Letter No. **C2/23548/94**

Sub:  MMDA - Planning Permission - Regulari-
sation of existing building and proposed
additional construction of factory build-
ing at S.No.190/50/28 of Pammal Village,
No.117, Thiruneermalai Main Road, Nagalkeni,
Chrompet, Madras-44 - Development charges
and other charges to be remitted - Regarding.

SHEET No. 1/2

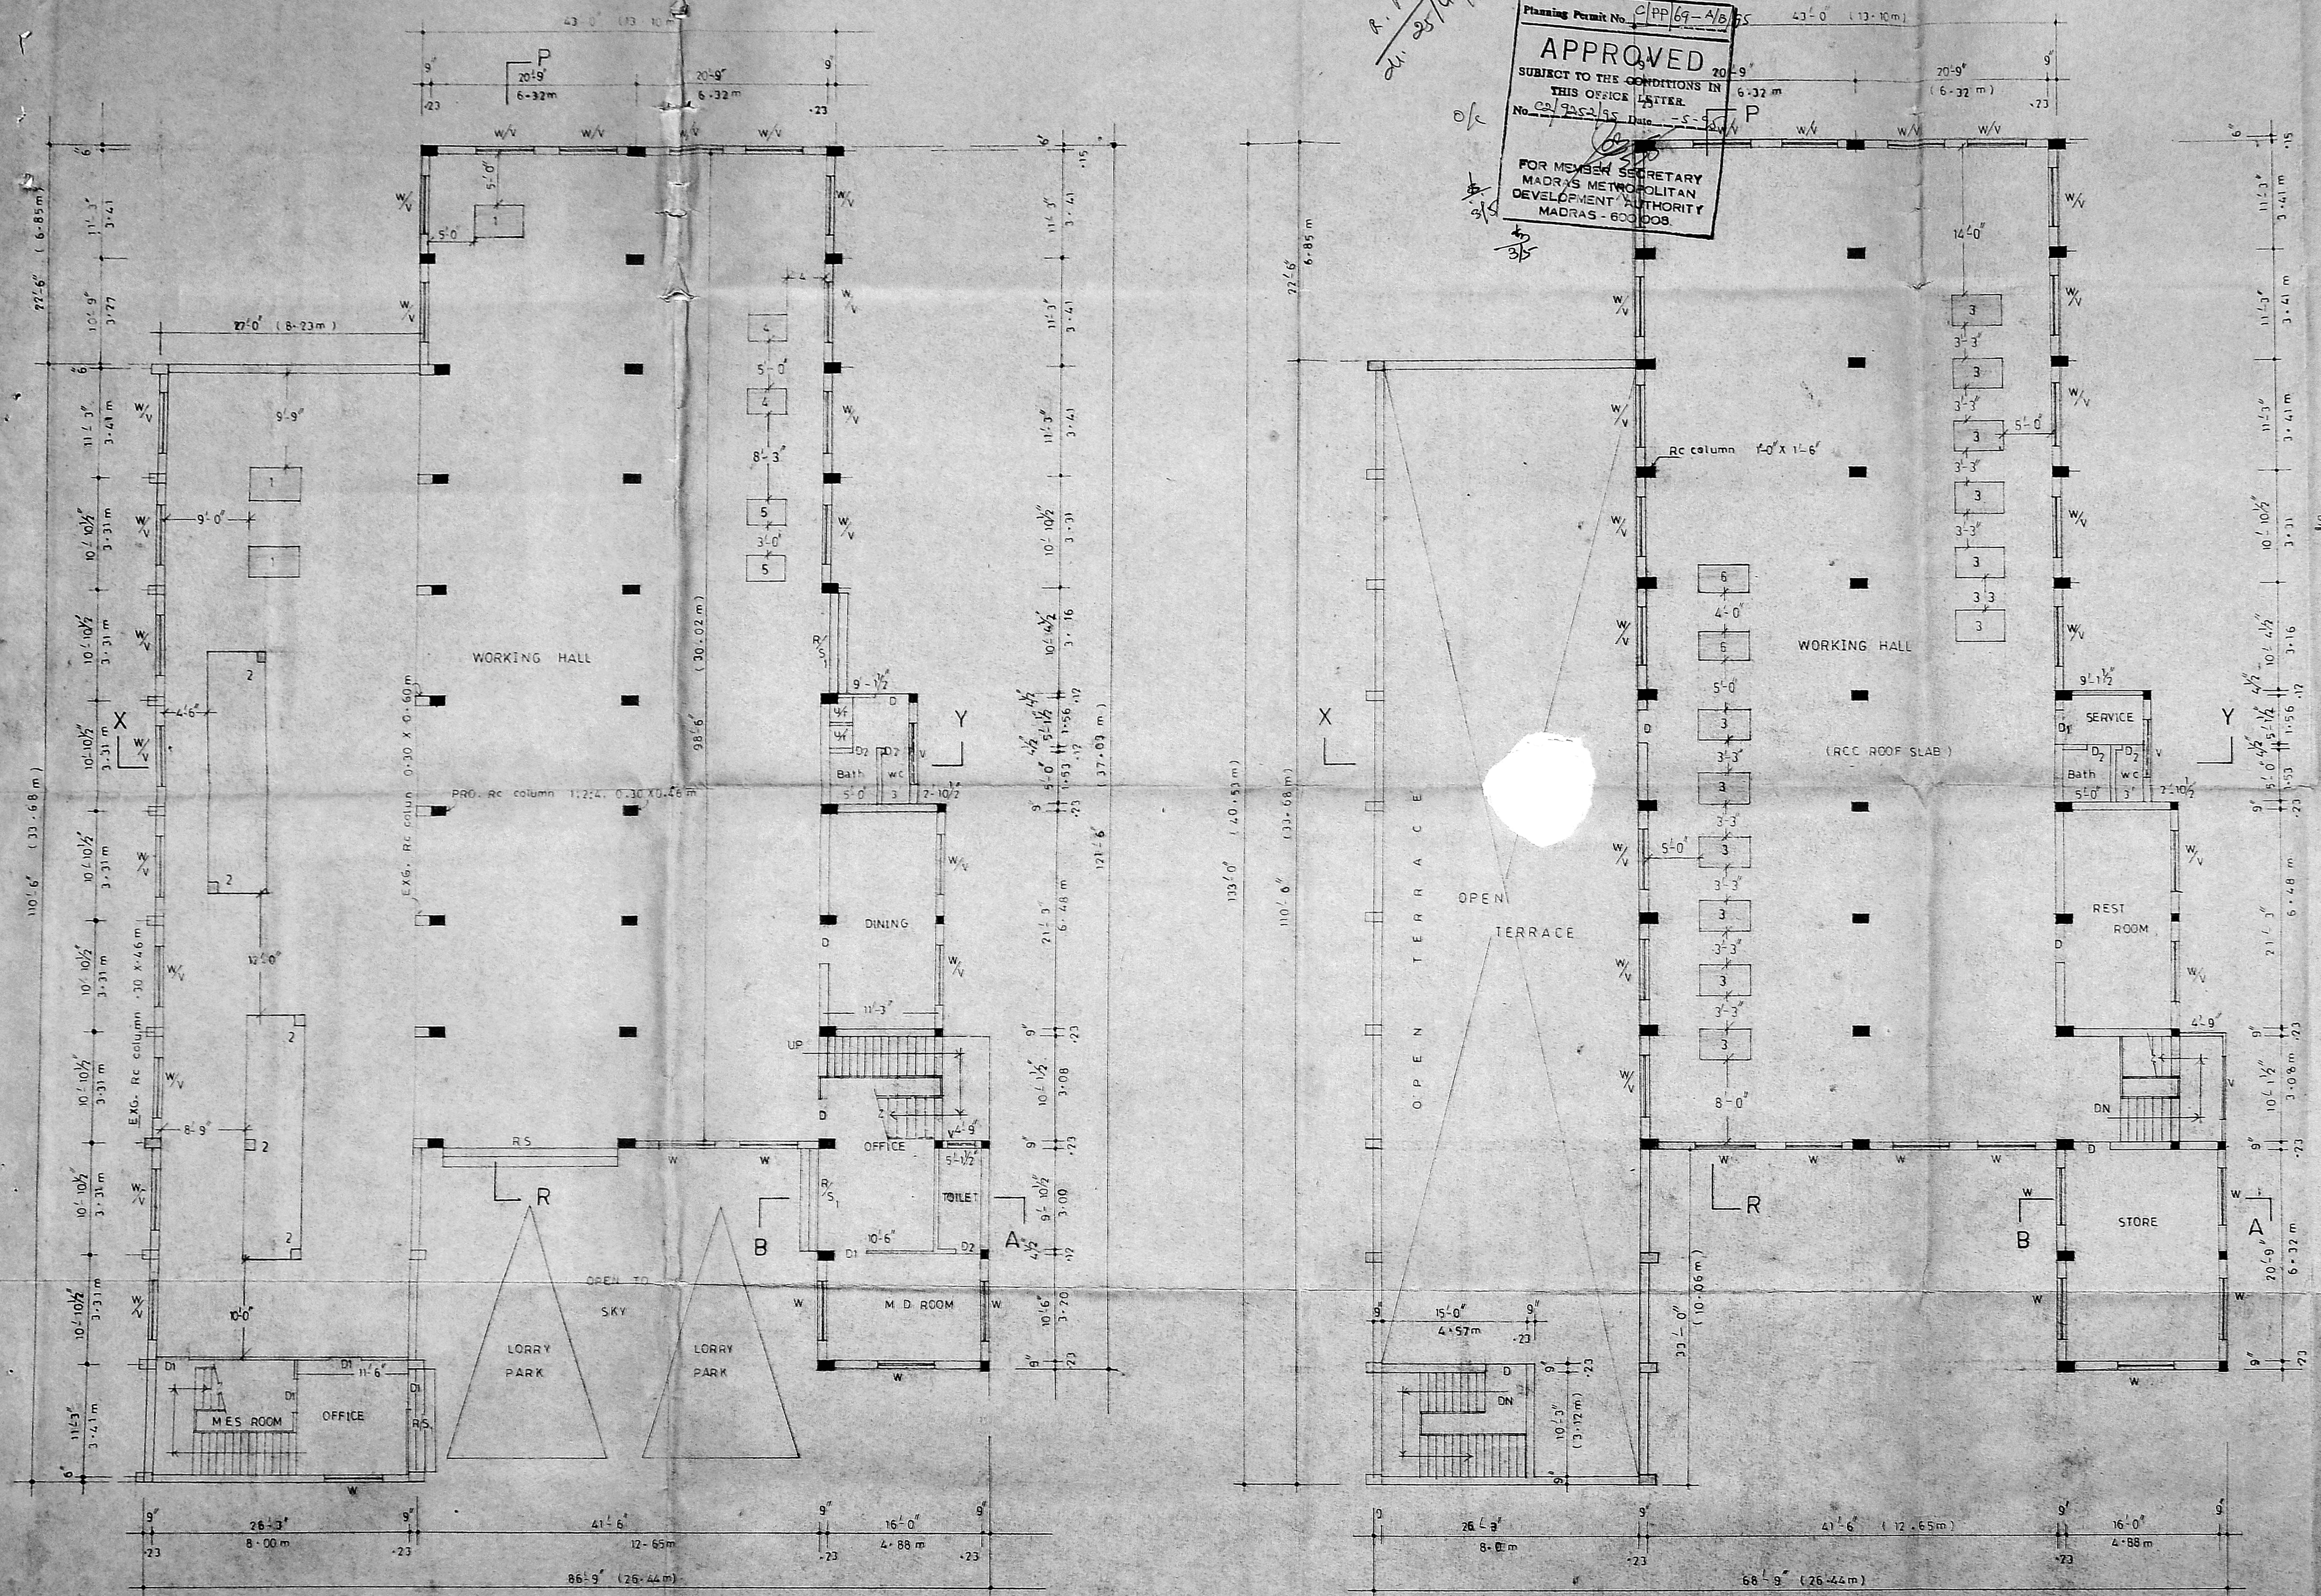
c) Revised Plan deleting the hooking dry yard in the 1st floor plan and changing the HP and machinery details tallying with the revised process chart.
